Objection to Planning Application WA/33/26/PL

Re: The Greenway, West Walberton Lane, Walberton BN18 0QS – Construction of a self-build/custom-build single dwelling, garage outbuilding and associated works

Land north of The Green Way
Appendix 6 - tree protection plan

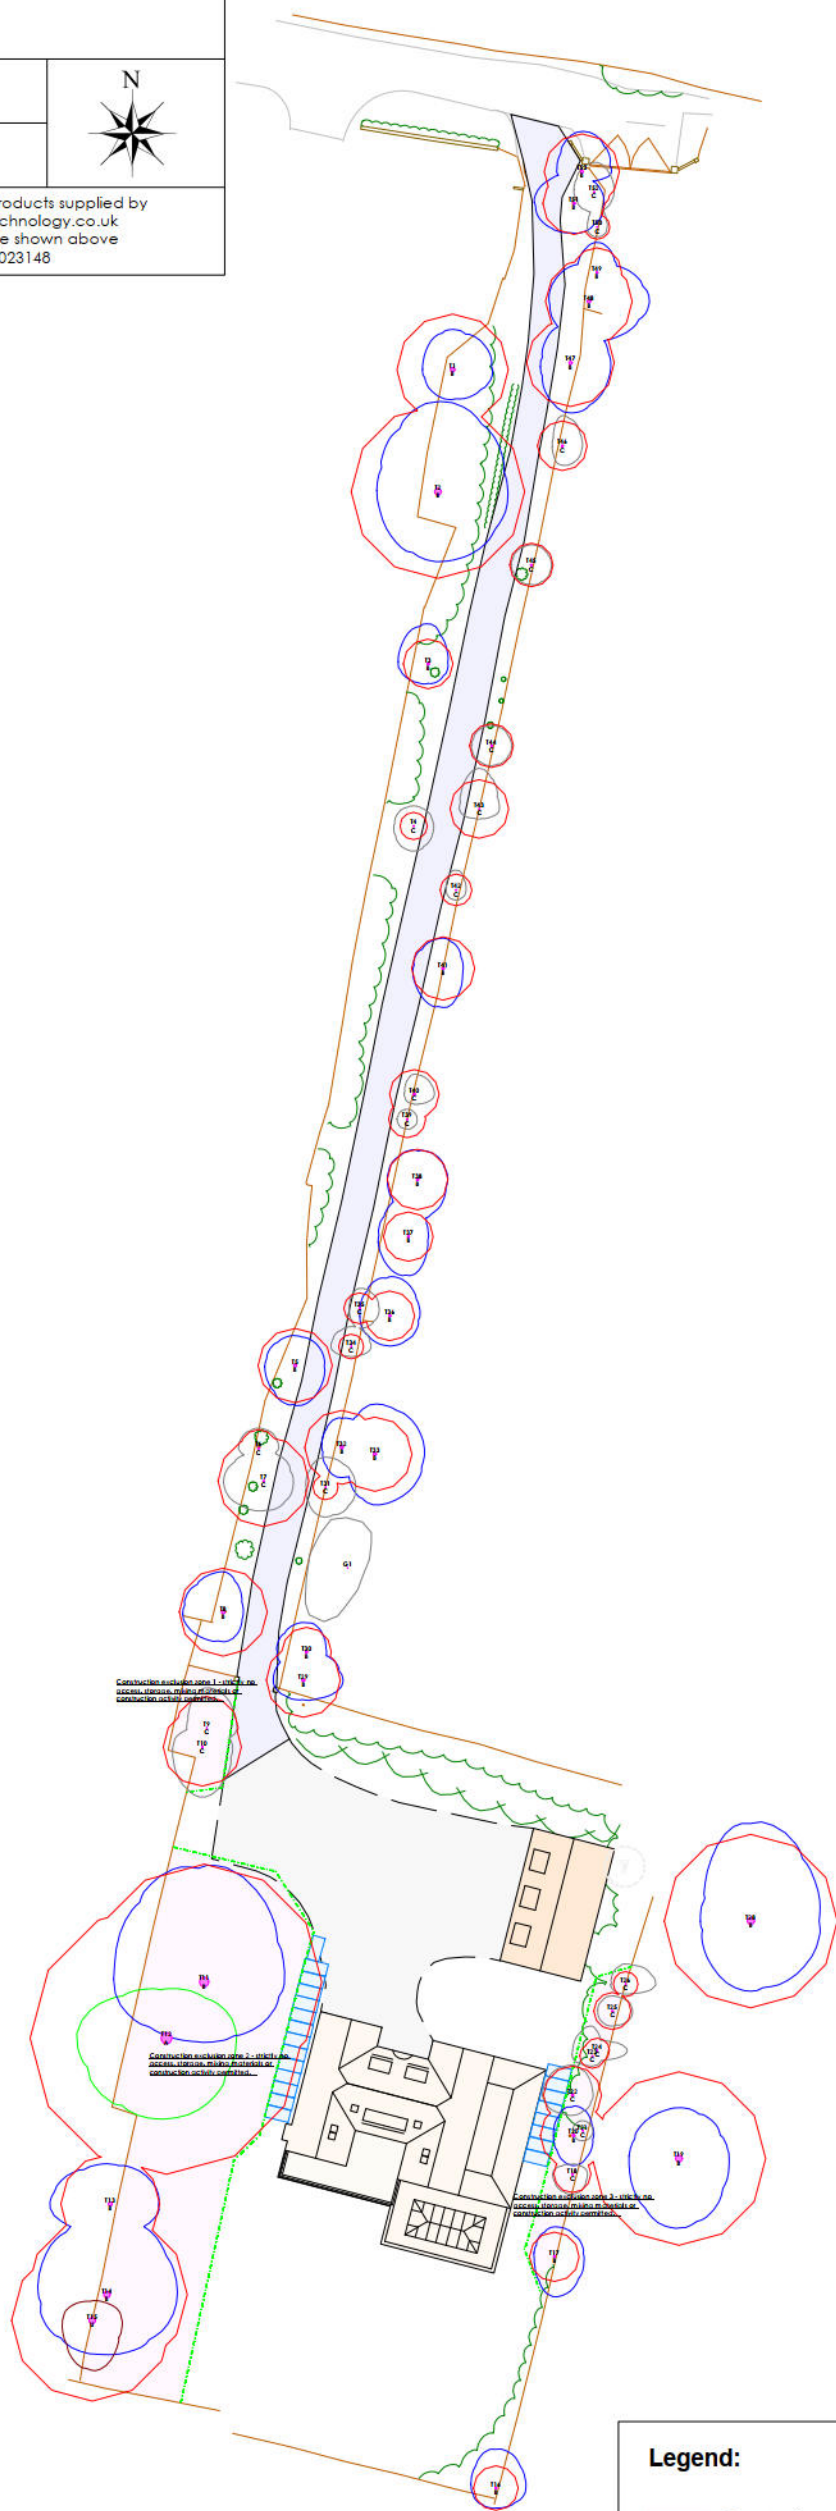
The arboricultural material identifies significant tree constraints, including protected trees and trees on neighbouring land. The proposed access and construction route appear to pass through Root Protection Areas, and the submitted documents do not convincingly show that access works, no-dig construction, drainage works and future maintenance can be carried out without unacceptable harm to those trees or their rooting environment. This is a fundamental constraint and should be resolved before any permission is granted.
